## WEST SUSSEX COUNTY COUNCIL CONSULTATION

| <b>FROM:</b>                    | WSCC - Highways Authority                                                                                                                                                                                       |
| <b>LOCATION:</b>                | Roundabout opposite Victoria Drive, Chichester Road, Bognor Regis, PO22 9LQ                                                                                                                                     |
| <b>SUBJECT:</b>                 | BR/239/20/TEL<br>Prior Notification under Schedule 2 Part 16 Class A for the installation of a new 19m monopole supporting 6 No. antennas with proposed supporting equipment cabinet and ancillary development. |

Title:
215 MAX CONFIGURATION SITE PLAN

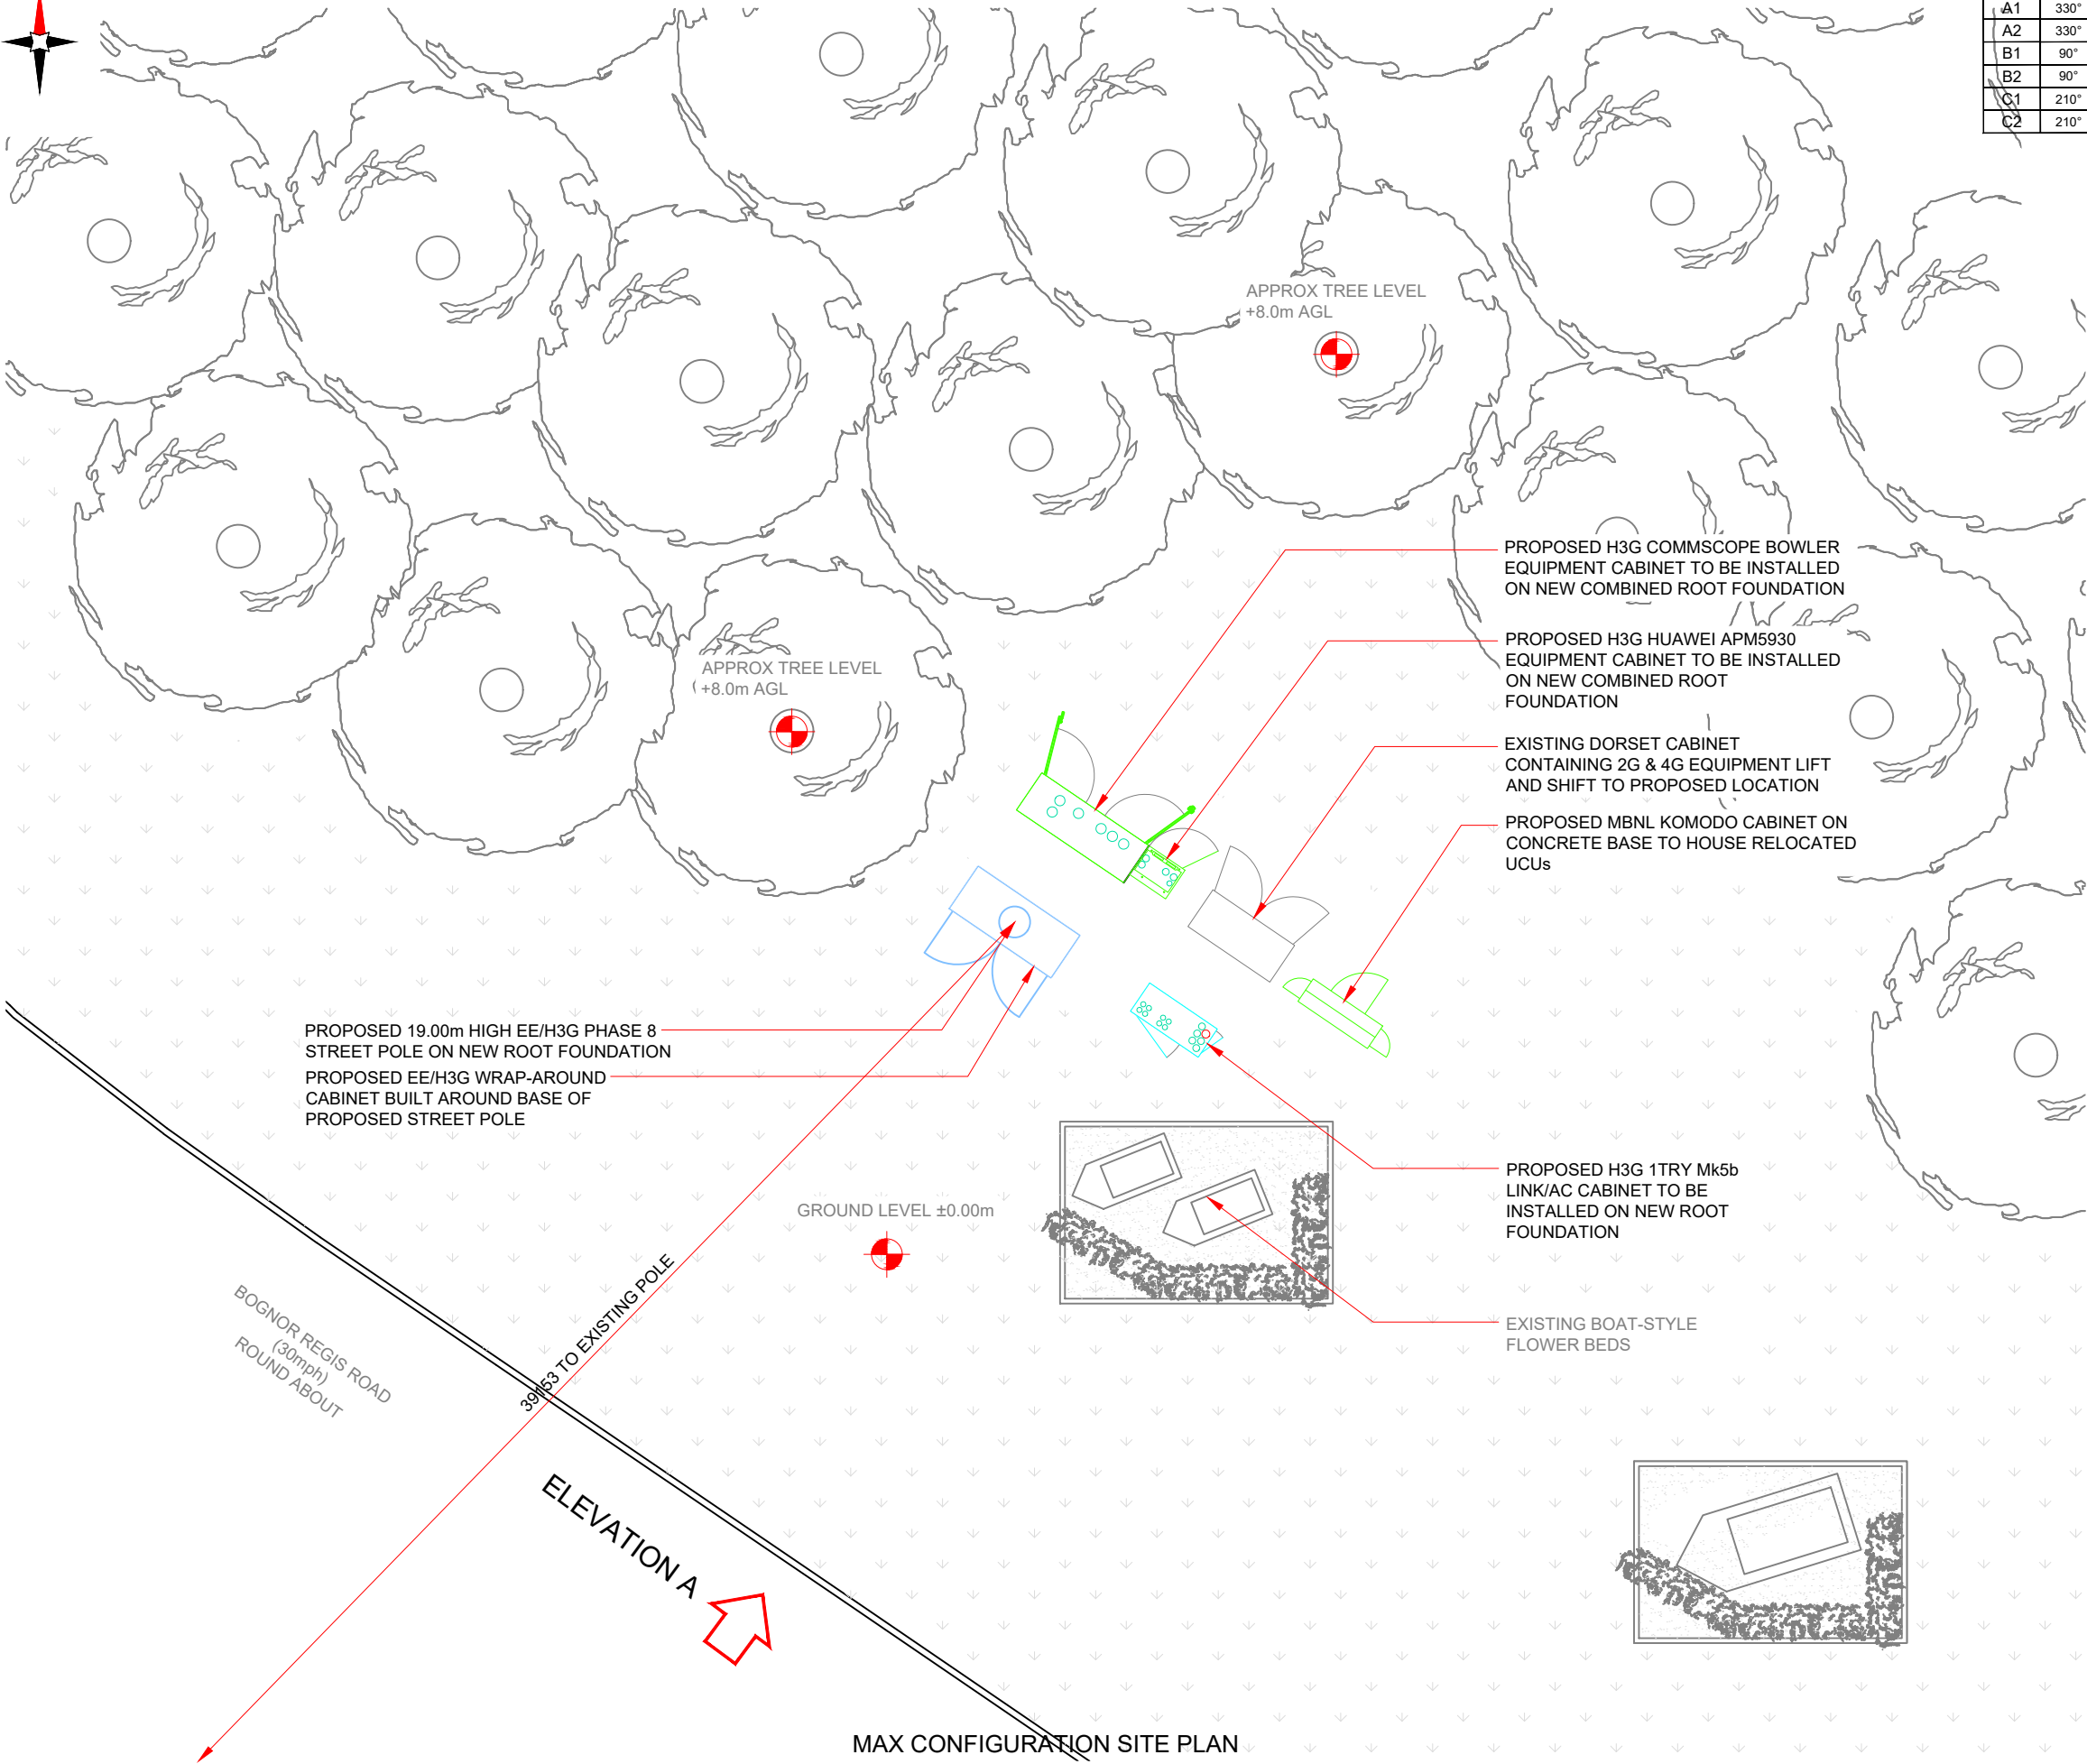
The proposed monopole and equipment cabinets are to be located within highway boundary, approximately 9.3m from the back edge of the carriageway. They are not anticipated to obstruct visibility for vehicles travelling along Chichester Road.

Chichester Road is sided by footways in this location. Therefore, the LHA does not anticipate that this proposal would result in an obstruction to any pedestrians who may be utilising or seeking refuge within the highway boundary.
